A66 Trans-Pennine Project Scheme 0102 – M6 Junction 40 to Kemplay Bank

SUMMARY of WRITTEN REPRESENTATION

This is summary of the Written Representation on behalf of Penrith Properties Limited in respect of the proposed acquisition of land Plot 0102-01-20.

Drawing Title
Land Plans
Regulation 5(2)(i)
Sheet 1 of 2

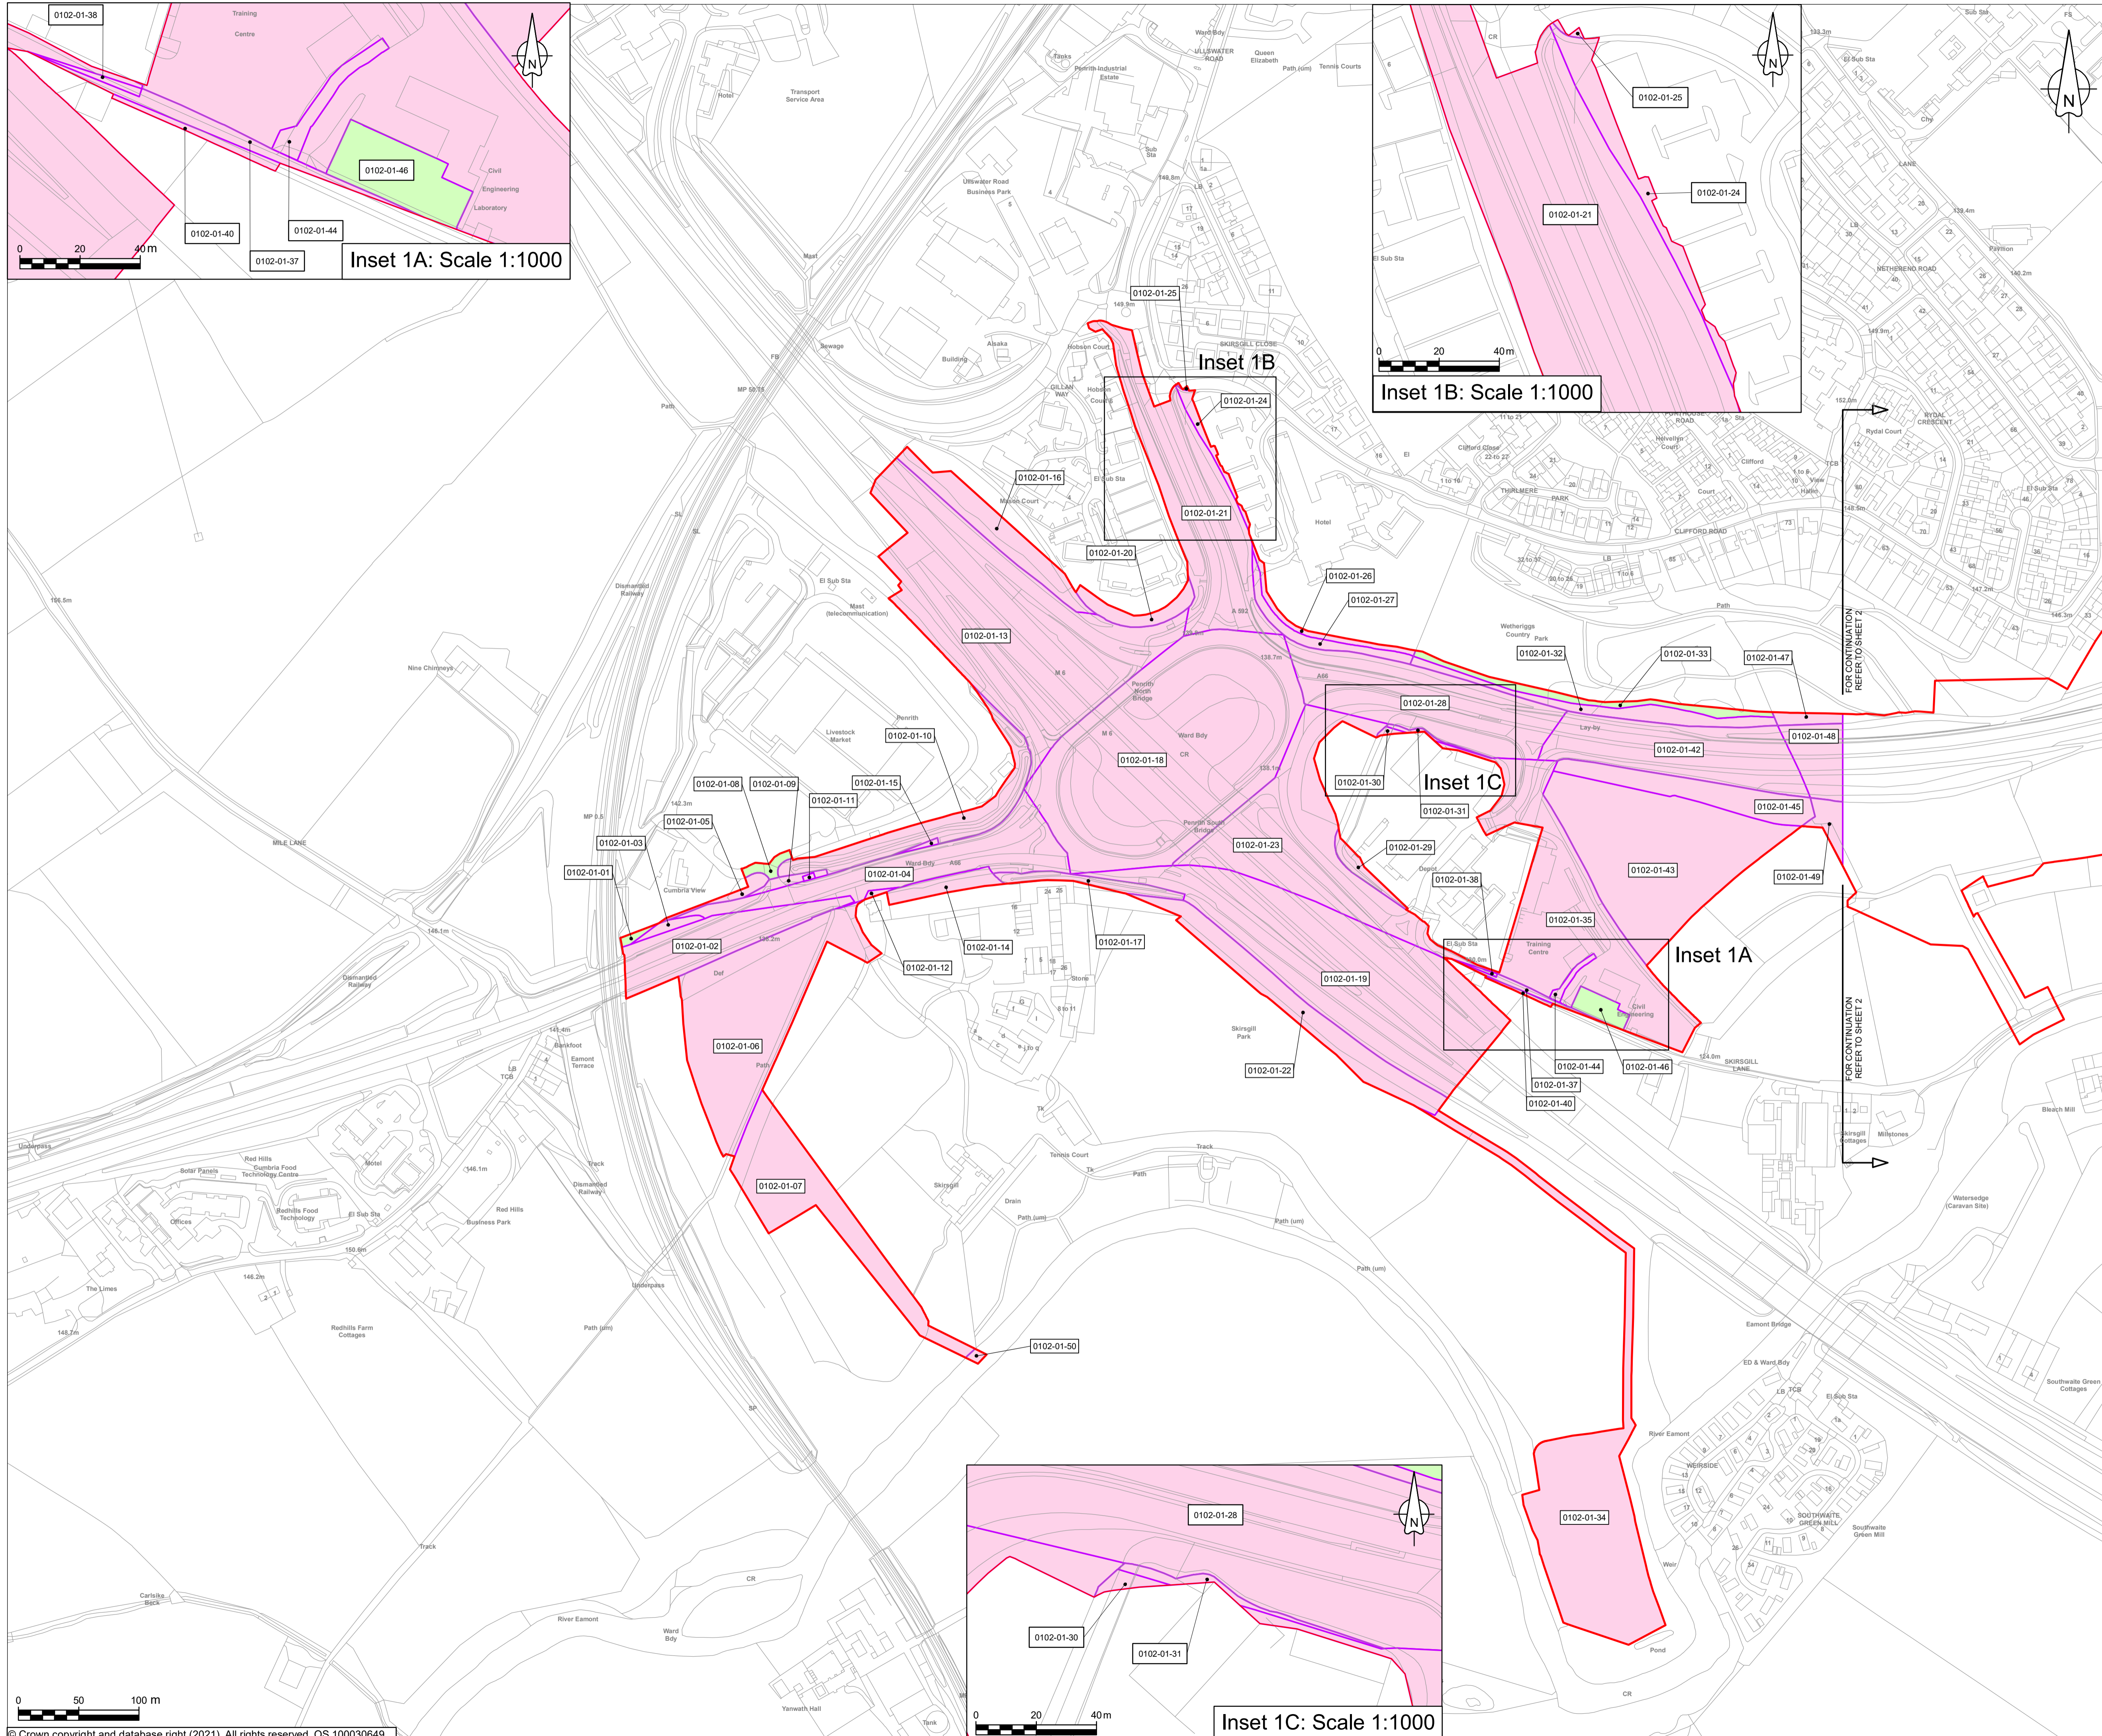
The extent of the land to be permanently acquired to the top of the landscaped slope that forms part of the structure of Ghyll Mount and includes all the tree planting that forms a natural screen for the building.

There are no sections provided by the Applicant in relation to the proposed works that affect plot 0102-10-20 that demonstrate the extent of the proposed changes to the existing levels/profile of the land within plot 0102-01-20.

There is no justification for seeking a shared cycleway route with a width that appears to be in excess of 6 metres which is very significantly in excess of desired minimum requirements set out by National Highways taking into account measured pedestrian and cycle movements.

Proposed traffic signals and traffic speeds mitigate the need for the excessive visibility requiring acquisition of the entire embankment.

The extent of land required is beyond that reasonably required for the 'Rochdale envelope' for deviation of routing given that land required is tied to the existing structures and carriageways.

Since no proposed works are identified within the majority of plot 0102-01-20 it is likely that existing established planting will be retained and therefore there is no need to permanently acquire the land.

PPL do not believe the land identifies as plot 0102-10-20 is required to enable the scheme be delivered for the reasons stated however in so far as it is strictly necessary for the scheme PPL would enable access by agreement to the land to carry out the works on the strict proviso that it is reinstated with an appropriate boundary treatment in its existing location.
